Subject: Y/17/20/PL and Stakers Farm/Land N of School

Yesterday I was contacted by our drainage engineers about your site and the commencement of the access. It was an oversight on our part that we did not consult engineers on the access only application Y/17/20/PL. Engineers have asked that I provide you with the following comments which you may find useful moving forwards.

Client			
DANDARA LIMITED (SOUTHERN)			
Scale	Date	Designed	
1:250 @A1	OCT 19	CJL	
Drawn	Checked	Approved	
CJL	SW	JHM	
Job No	Drawing No		Rev
19-156	YAP-S278-01		J

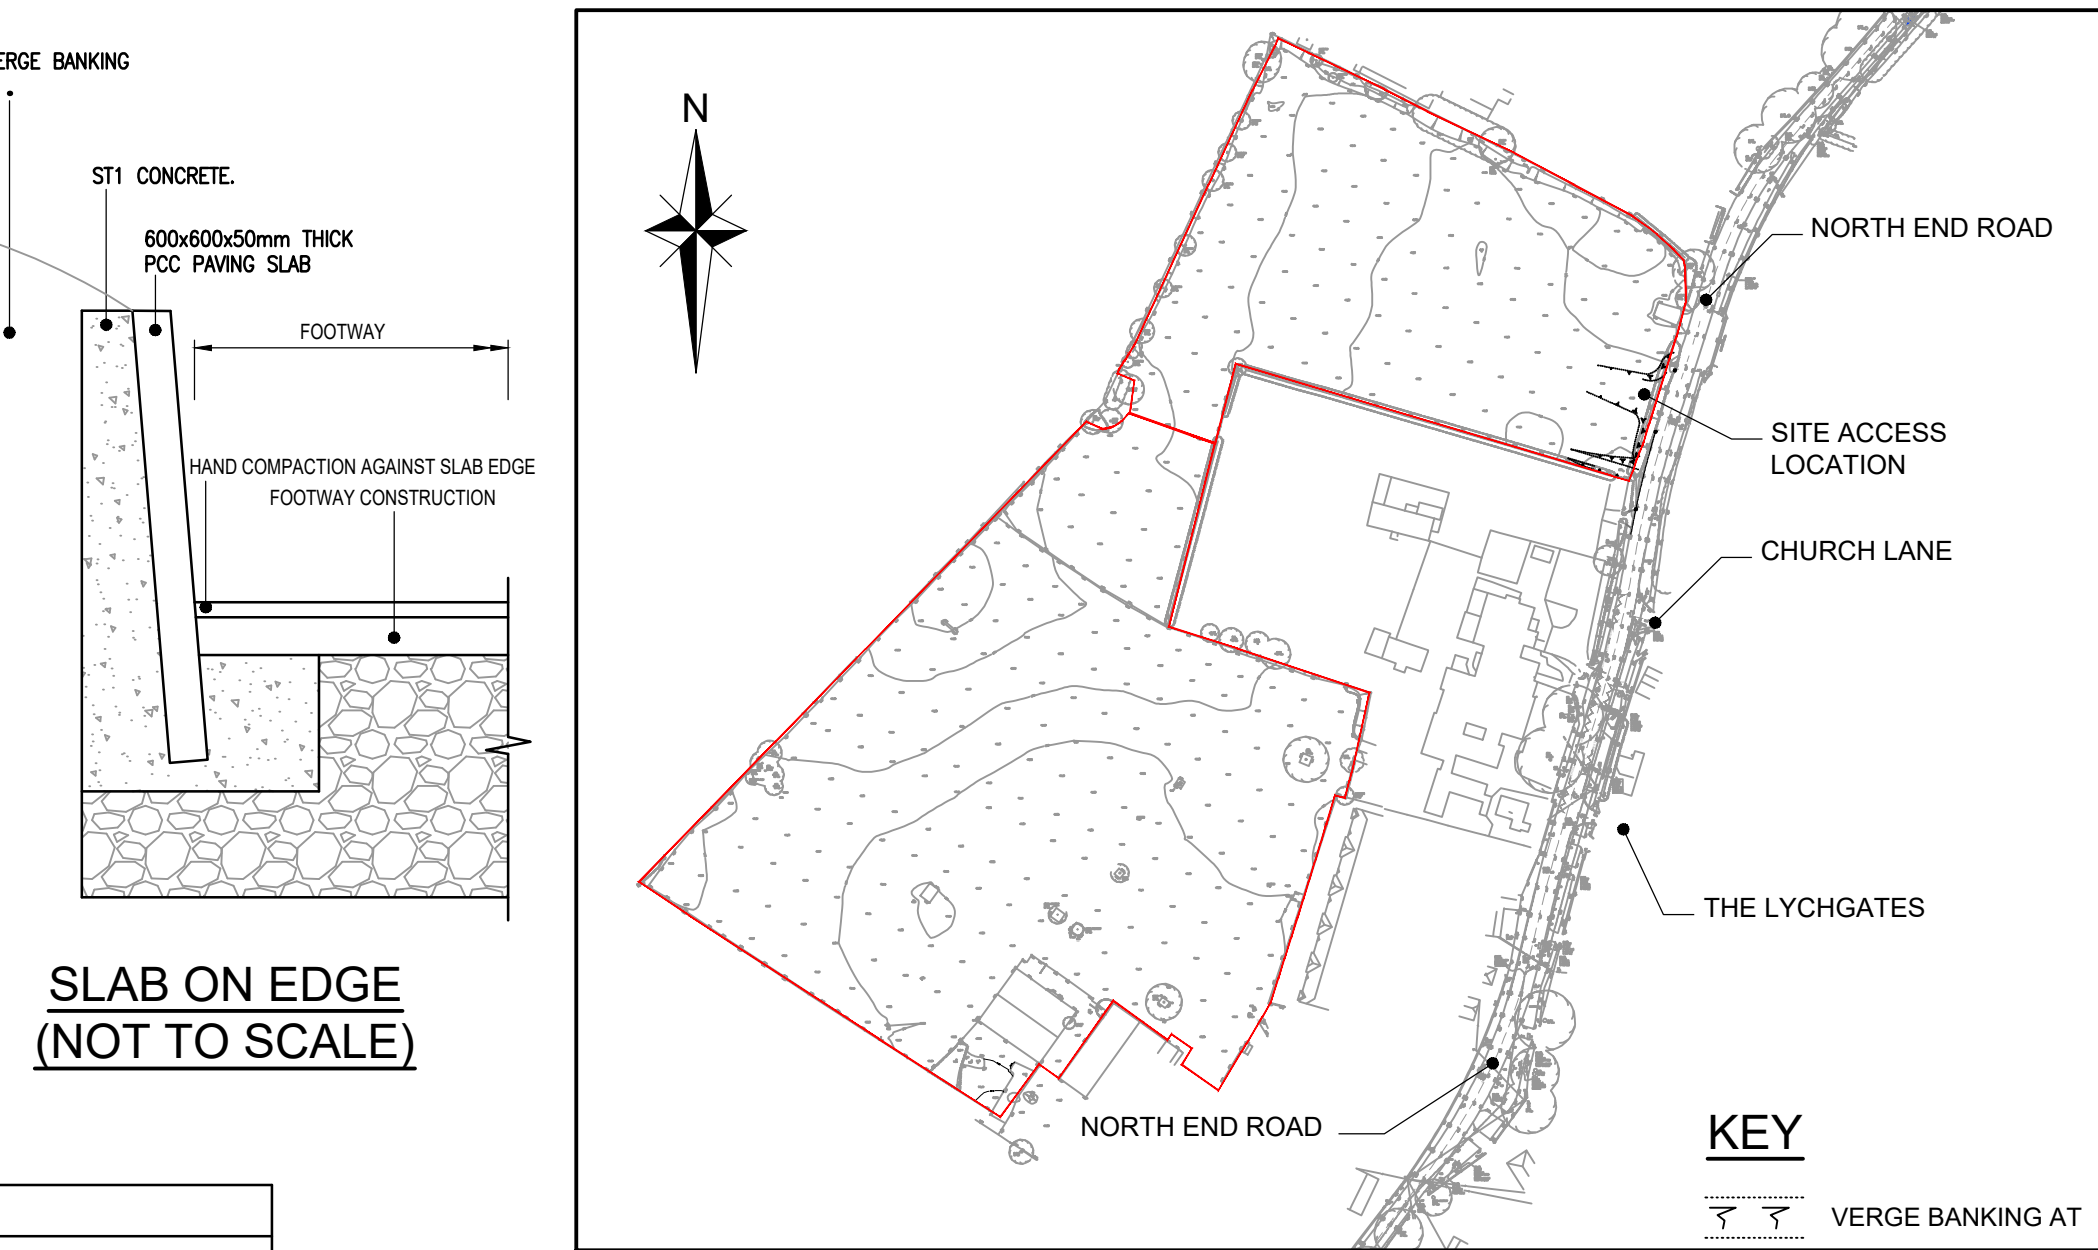
The access road shown within the red line boundary on application Y/17/20/PL consists of impermeable surface between North End Road and the highway boundary. From the highway boundary, the rest of the access road and indeed all roads on the remainder of the site are to be of a permeable construction and will form part of the Surface Water Drainage Strategy for the site.

Therefore in constructing part of the permeable access road as approved under Y/17/20/PL the applicant runs the risk of the constructed access conflicting with the Surface Water Drainage Strategy if/when it is agreed via condition. Elements of the permeable paving construction will be agreed via condition, for example, the materials used, the depth of construction, and the location of baffles (which I understand are required on this site). Please make the applicant aware of this potential conflict. If the permeable paving constructed under Y/17/20/PL conflicts with the eventually approved Surface Water Drainage Strategy/Layout, it is expected that this will be reconstructed in accordance with approved plans.
